Charlotte Storm Water
600 East Fourth Street
Charlotte, N C 28202-2844

Rezoning Petition Review

Date of Review: January 13, 2021

Rezoning Petition #: 20-195

**REZONING PETITION FOR REA ROAD TOWNHOMES**  
4245 REA ROAD  
CHARLOTTE, NORTH CAROLINA

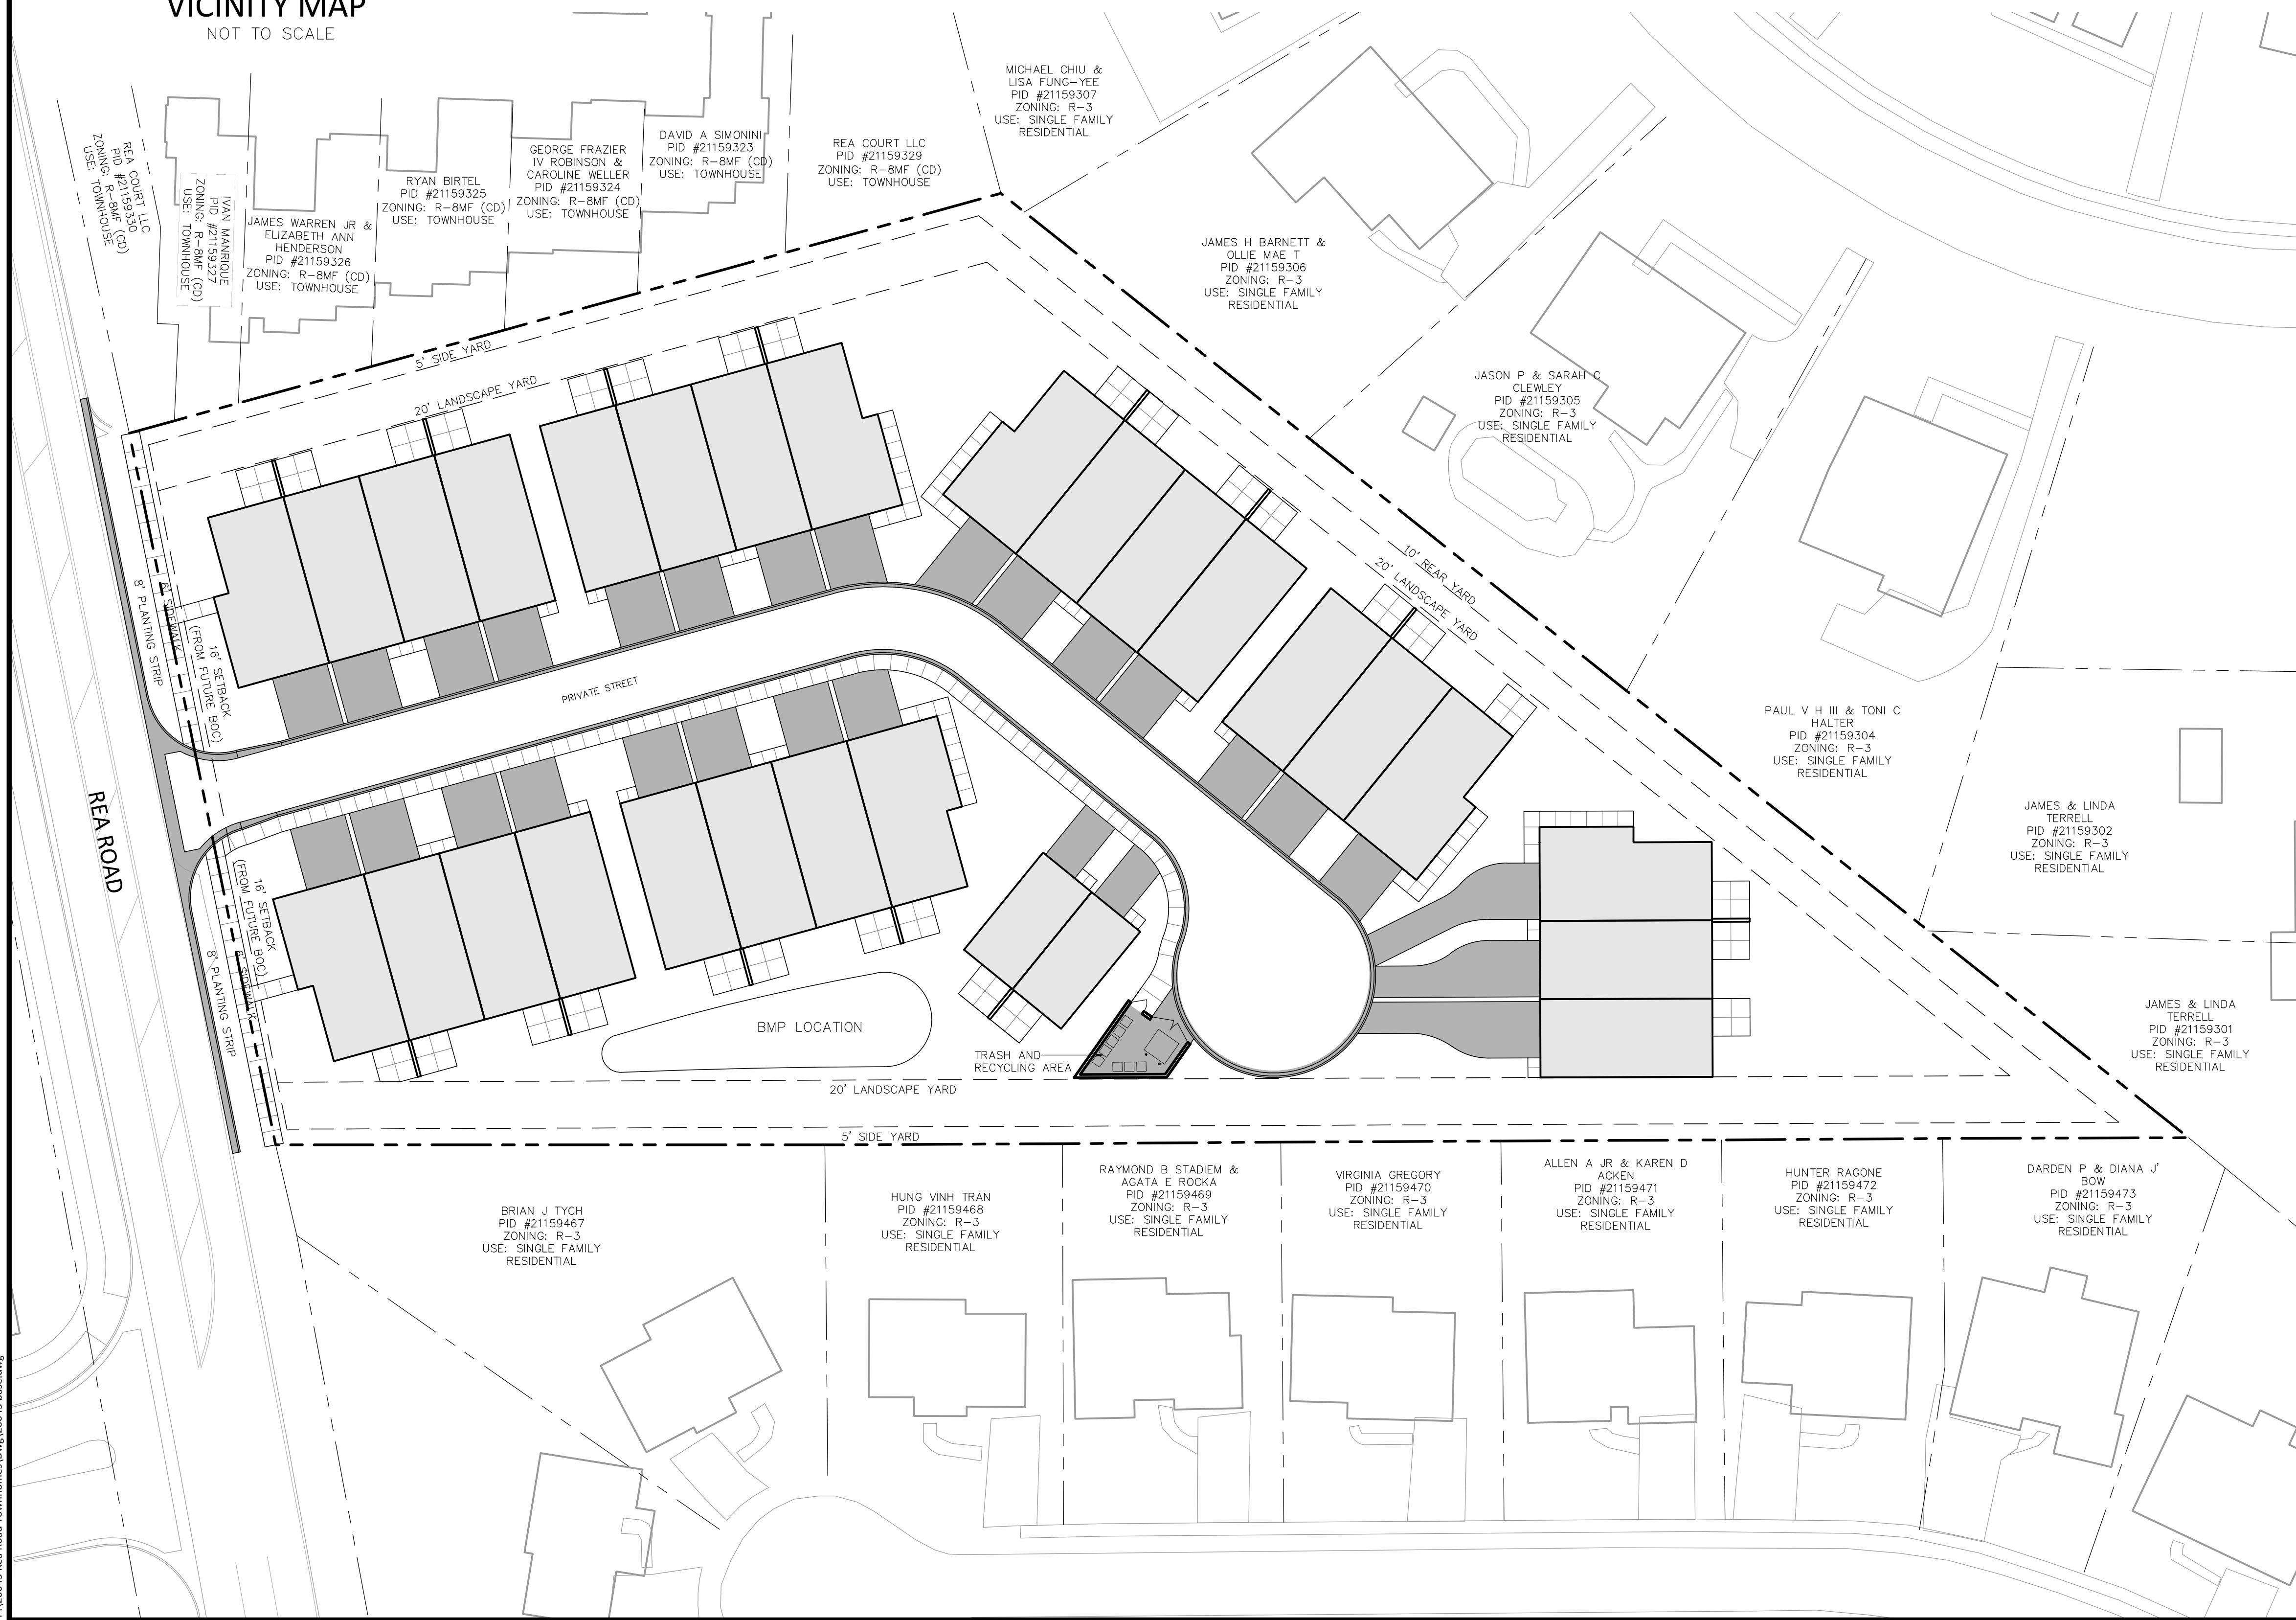
Please include the following note under Environmental Features. *The petitioner shall analyze the adequacy of the existing storm water conveyance to the nearest public right-of-way. If the existing storm water conveyance is found to be inadequate, the Petitioner shall make a good faith effort to improve the storm water conveyance or mitigate the storm water discharge.*

This property drains to McAlpine Creek, which is an impaired/degraded stream, and may contribute to downstream flooding. This project has the opportunity to mitigate future impacts to this stream, therefore, Storm Water recommends placing the following notes on the plan:

(I) Storm Water Quality Treatment

For defined watersheds greater than 24% built-upon area (BUA), construct water quality stormwater control measures (SCMs) designed for the runoff generated from the first 1-inch of rainfall for all new and redeveloped BUA associated with the project. SCMs must be designed and constructed in accordance with the Charlotte-Mecklenburg BMP Design Manual.

(II) Volume and Peak Control

For defined watersheds greater than 24% built-upon area, control the entire volume for the 1-year, 24-hour storm for all new and redeveloped BUA associated with the project. Runoff volume drawdown time shall be in accordance with the Charlotte-Mecklenburg BMP Design Manual.

For commercial projects with greater than 24% BUA, control the peak to not exceed the predevelopment runoff rates for the 10-yr, 6-hr storm and perform a downstream flood analysis

to determine whether additional peak control is needed and if so, for what level of storm frequency, or if a downstream analysis is not performed, control the peak for the 10-yr and 25-yr, 6-hour storms.

For residential projects with greater than 24% BUA, control the peak to not exceed the predevelopment runoff rates for the 10-year and 25-year, 6-hour storms or perform a downstream analysis to determine whether peak control is needed, and if so, for what level of storm frequency.
